Rezoning Transportation Analysis

Petition Number: 2024-008

| Date | Description |
|---------|-------------------|
| 2-21-24 | First Review (NK) |

RZ01 - REZONING PLAN

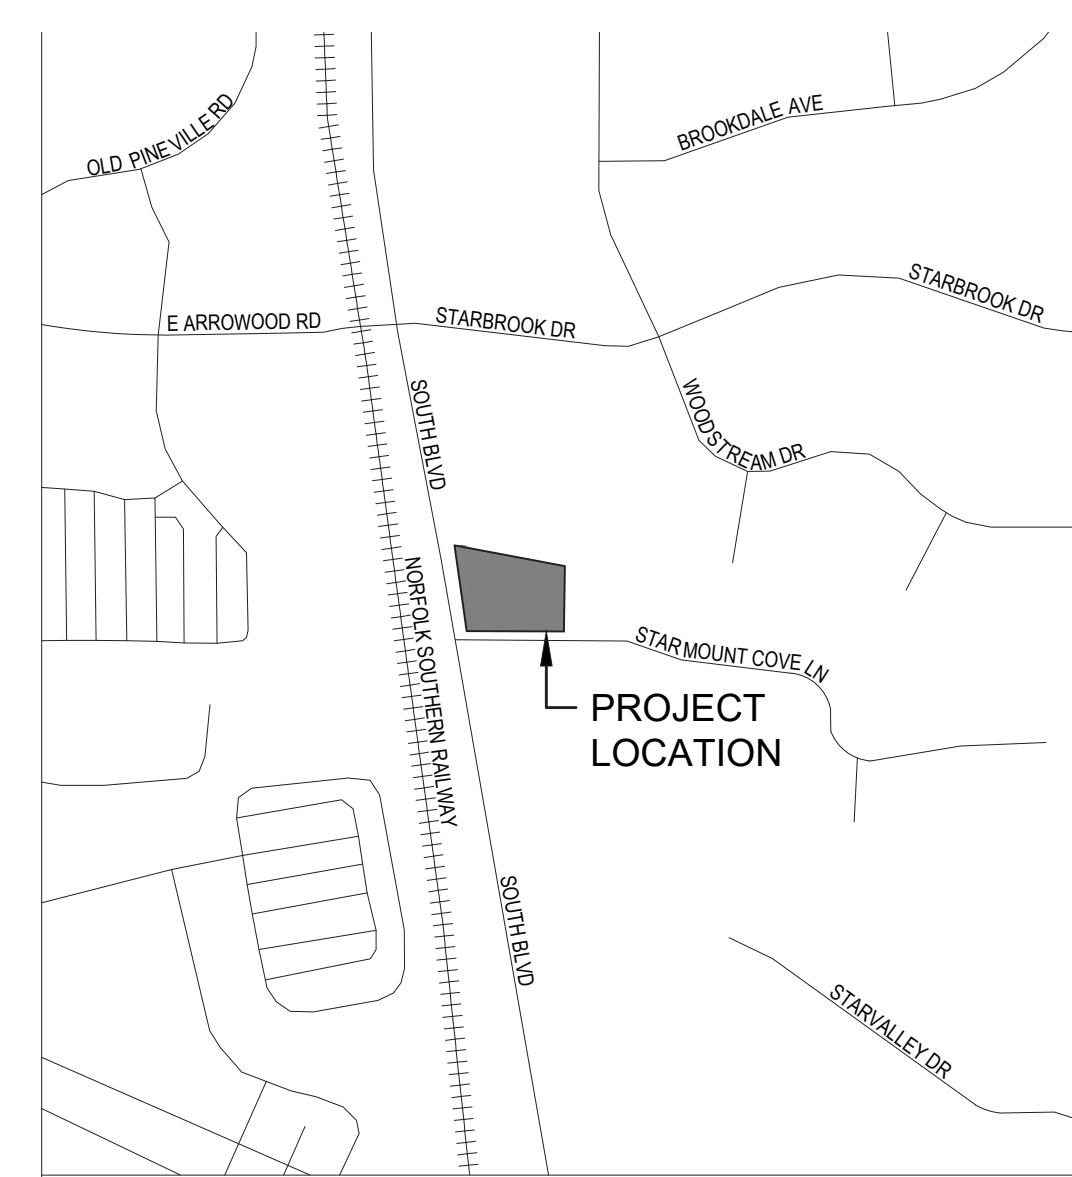
- a. **Road Name South Boulevard:** The future location of the back of curb and gutter is 38' from the road centerline.

Label and dimension the curb and gutter from the centerline for each road on the site plan.

- b. **Road Name Starmount Cove Lane:** The future location of the back of curb and gutter is 20.5' from the road centerline.

Label and dimension the curb and gutter from the centerline for each road on the site plan.

- 3. Revise site plan and conditional note(s) to commit to dedicate 56' right-of-way from the South Boulevard road centerline. The site plan shall label and dimension the right-of-way from the road centerline.
- 4. Revise site plan and conditional note(s) to commit to dedicate 38.5' right-of-way from the Starmount Cove Lane road centerline. The site plan shall label and dimension the right-of-way from the road centerline.
- 5. Add a conditional note specifying "A Right-of-Way Encroachment Agreement is required for the installation of any non-standard item(s) (irrigation systems, decorative concrete pavement, brick

6. Revise site plan and conditional note(s) to commit to installing 8' planting strip and 8' sidewalk along South Blvd and Starmount Cove Lane per UDO article 32.7. Streetscape should be located at the future back of curb location.

7. Revise site plan and conditional note(s) to commit to removing driveway located on South Boulevard. Per Charlotte Streets Manual table 2.1, access priorities would be as follows before individual driveway:
